# CITY OF ALBUQUERQUE

June 25, 2018

**Re: O'Reilly Auto Parts-8001 Ventura NE  
Erosion and Sediment Control Plan  
Engineer's Stamp Date 6-15-18 (D20E010C)**

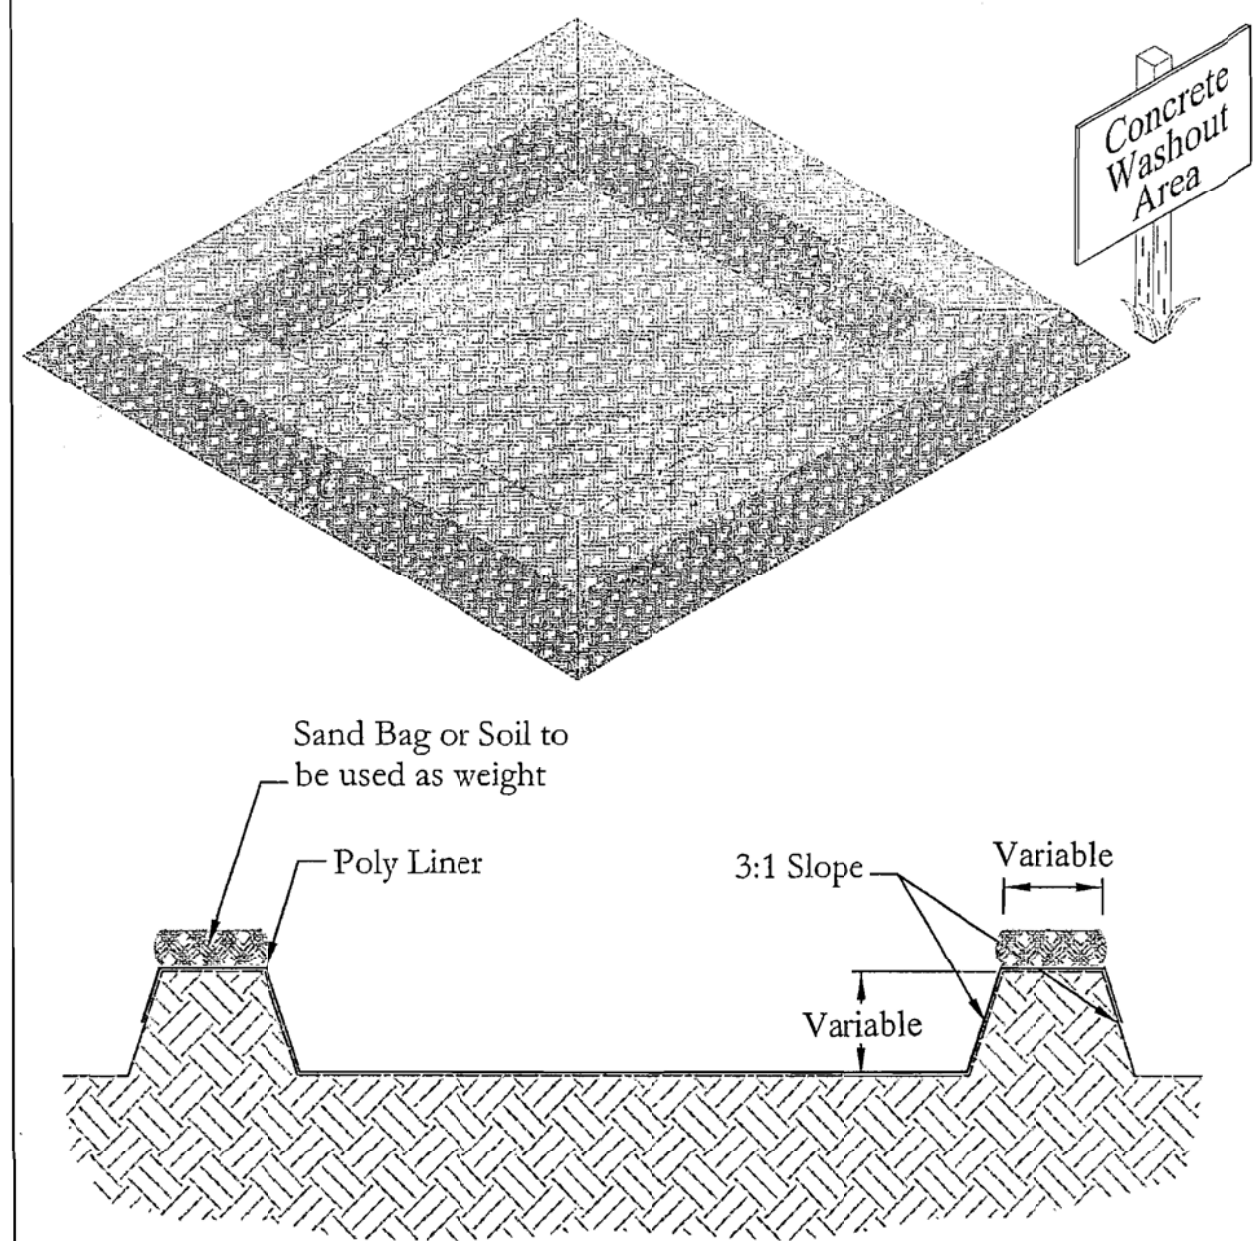
1. It appears the access drive along the western edge of the site is to be graded. If so, the sediment BMP (e.g. silt fence) along the western edge is to be moved to the west edge of the disturbed area(s).

- a. This access drive is the only exit for three businesses, so it will most likely need to be left open.
- b. Provide a sediment BMP at the inlet to the pond/channel in the southwest area located just off the site to prevent sediment and wastes from entering the pond/channel.
- c. Provide a sediment BMP in the northwest corner to prevent sediment and wastes from leaving the site.

2. The track-out pad is shown on an existing access drive. It does not appear they are removing the access drive. The track-out pad may need to be relocated.
